RE: PAX12.324290 - 10-year planning permission for Lissinagroagh Wind Farm consisting of 14 no. wind turbines and all associated infrastructure

Planning Ref: PAX12.324290

RE: PAX12.324290 - 10-year planning permission for Lissinagroagh Wind Farm consisting of 14 no. wind turbines and all associated infrastructure AT townlands of Boleyboy, Cashelaveela, Cherrybrook, Killea, Coolodonnell, Faughary, Lissinagroagh, Lisdarush, Lugasnaghta, Raheelin, Shashmore, Tawnyfeacle and Tullysheherny, County Leitrim.

SITE LAYOUT PLAN
 Sheet 1 of 9

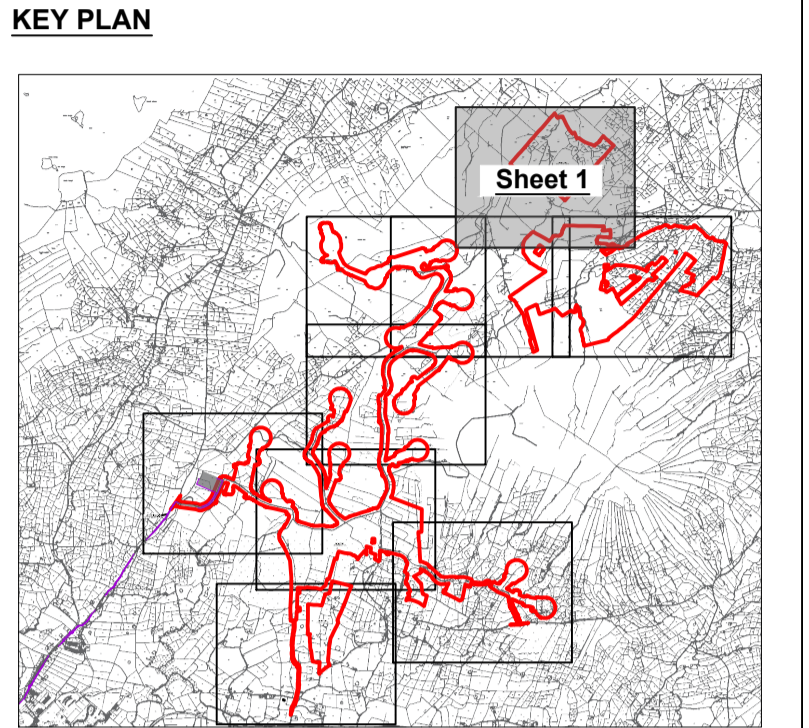
The Heritage Council's firm position is that the location of development, as well as the site layout and design of schemes, should be informed by the environmental constraints and heritage sensitivities. Following a review of the Landscape and Visual Chapter and the Cultural Heritage Chapter, we have considerable concern regarding the siting of Turbine T03.

The EIAR has rightly discussed this landscape in its assessment of impacts. It has also rightly pointed out that Turbine T03 is in a prominent position and is likely to be visible from all directions (See 14.3.11.1). There is also potential for other archaeological features in the area around this turbine. Turbine T03 is located within 146metres of a ring cairn and cist (LE008-006001 and LE008-

In general terms, the Heritage Council recommend that this turbine needs to be removed from this location with the primary consideration being the setting of the cairn and cist monument, and its corresponding visual relationship with the barrow on Croknagapple.

We would also point out, with due regard to Table 14-5 that a 'medium' magnitude effect on a 'high' sensitivity receptor should not be confined to 'moderate' significance. In this case, we believe that when the visual connection between both monuments is considered, that there is a higher significance of effect in EIAR terms, and this justifies the removal of Turbine T03.

0.89 hectares of cutover bog (PB4) habitat which corresponds to Annex I habitat type 7130 Blanket bog (inactive) will be lost (section 5.6.2.3.2). Incidentally, this is the result of Turbine T03, the construction of which will see a direct loss of this habitat. This has resulted in an EIAR assessment of *negative, permanent, irreversible, likely significant effect* at local geographic scale on this habitat. The construction of Turbine T03, along with others (T4 and T10) will also affect the hydrological regime associated with this habitat, and results in a further indirect degradation of 1.65ha of cutover bog (PB4) (Section 5.6.2.3.2.2). Even with mitigation, the reporting concluded potential for *significant residual effects* at a local geographic scale (Section 5.6.2.3.2.9).

In addition, section 5.6.2.3.17.1 notes that 0.55 hectares of upland blanket bog (PB2), which also is identified as corresponding to Annex 1 habitat type 7130, will be lost to the construction of Turbine T03. Again, impacts arising from the construction of T03 and T04 on the wider hydrology is estimated to result in the potential further degradation of 2.64 hectares of this habitat.

With regards to dry siliceous heath (HH1)/dry humid acid grassland (GS3), which corresponds to Annex I habitat type European dry heaths, a total of 0.45ha of the total mosaic will be lost, again due to of the proposed construction of Turbine T03. The EIAR notes that this habitat loss represents a significant portion of the total 1.48ha of the habitat identified within the survey area for the proposed wind farm site. The reporting summarises a potential for significant residual effects at a local geographic scale for this habitat.

The final Annex 1 habitat type is exposed calcareous rock (ER2) corresponding to the priority Annex I habitat type 8240* limestone pavements. A small area of this will be lost due to the access track construction for Turbine T03.

While there are varying impacts on habitats from this application, the location of Turbine T03 is particularly egregious, and its current siting location does not comply with the named biodiversity policies from the adopted Leitrim County Development Plan 2023-2029.

It is clear to the Heritage Council that the decision to include Turbine T03 is ill conceived and is contrary to the principle of an environmental constraints led approach to siting and design. This specific turbine location will result, in our view, a significant negative effect on an important archaeological landscape, by virtue of the disruption to sightlines between corresponding monuments, while also resulting in significant negative effects on several Annex I habitats. It is clear that this turbine needs to be removed from the scheme design for its combined negative effects on both cultural and natural heritage receptors.
